10 August 2022

**North Sydney Public School**

**Stormwater Statement Letter - Modification 4.55**

DRAWING NUMBER
520128
PROJECT No.
NSPS-AUR-00-00-DR-CC-0030
REV
C

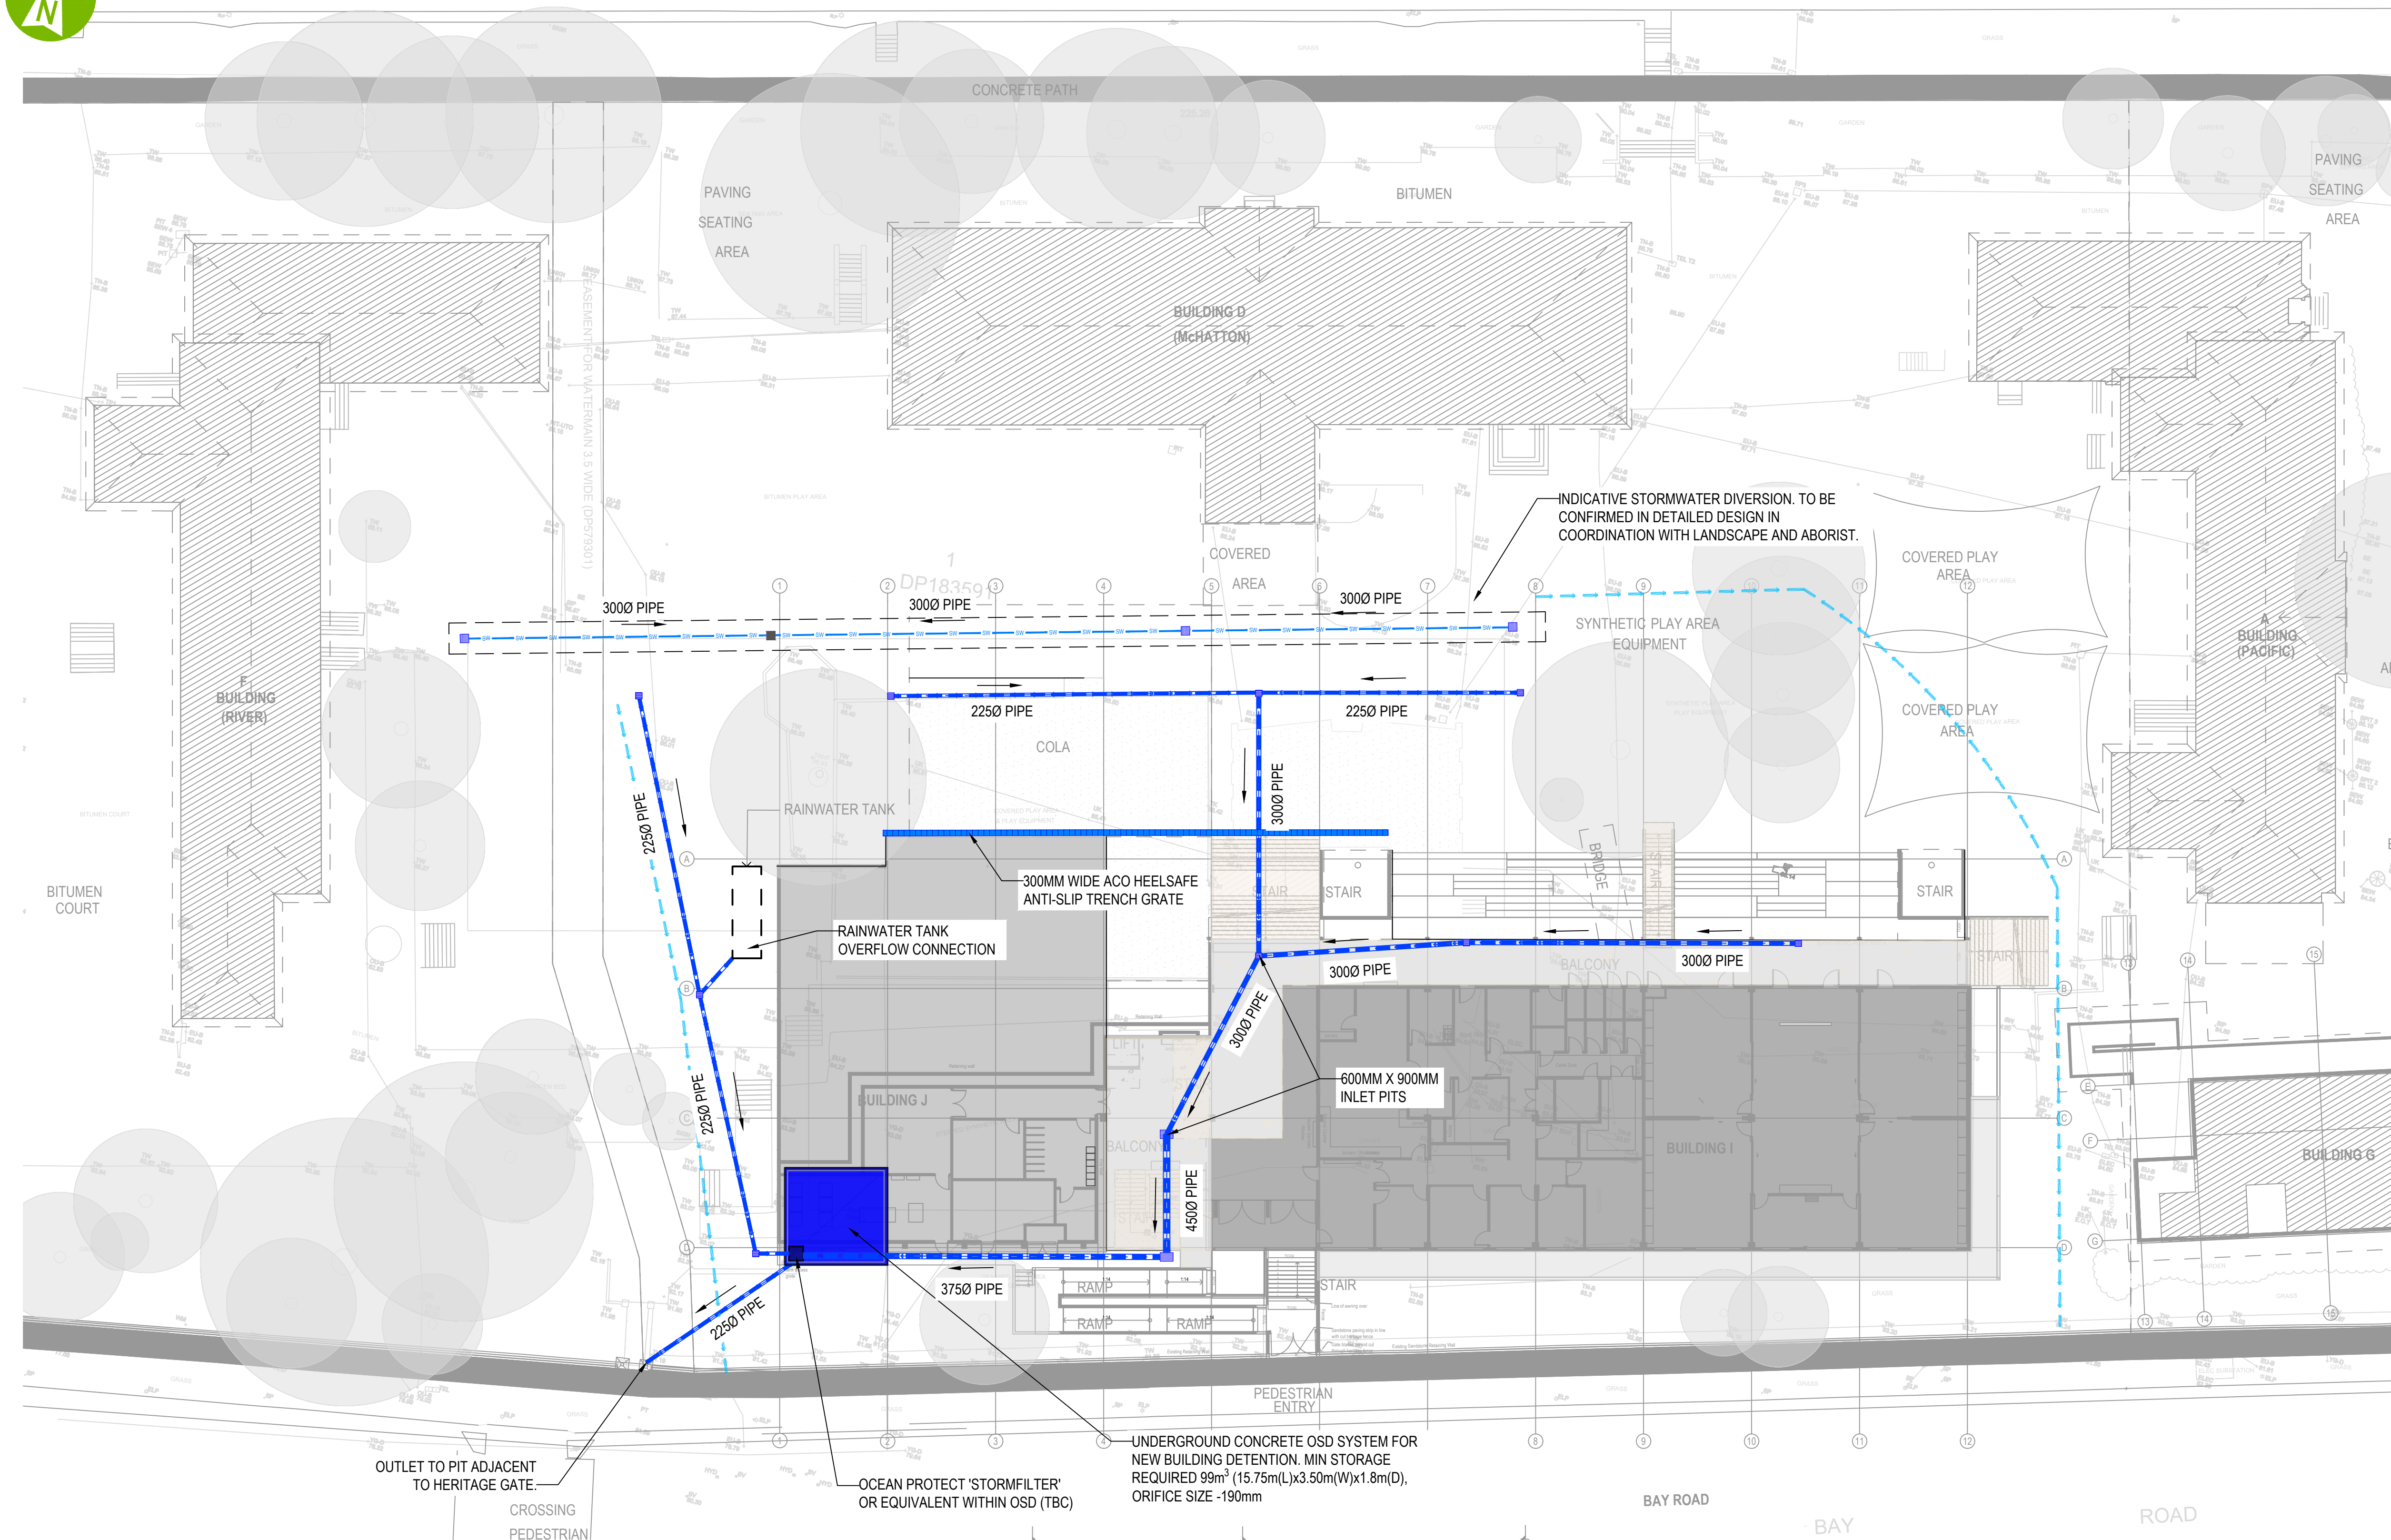
The plans show that the new school drainage will connect to the small pit (marked as pit 1 in the plans) in the footpath at the existing pedestrian crossing.  
This pit is only a small converter that was built as a temporary measure to divert water away from the school entrance and pedestrian crossing.

The stormwater from the school site should be managed appropriately and connected into the Council Drainage pipe system at the end of the school grounds in Bay Road, near the walkway to McHatton Street.

It is unknown if the open channel that runs along the edge of the school has the capacity for the additional drainage. This will be your responsibility to determine.  
You will also need to ensure that the additional drainage is not making the downstream drainage system worse as a result of the works. In this regard, DRAINS modelling is required.

After liaising with North Sydney Council and investigations on site, it has become evident that the flow conveyance capacity of Council's inground pipe system at the currently approved point of connection is inadequate for the proposed development. We therefore required to connect the site's drainage further downstream via an OSD system and diversion line. The most viable option is the existing channel, which has the capacity to accept the design flows. Please refer to the attached correspondence with North Sydney Council on the following pages.
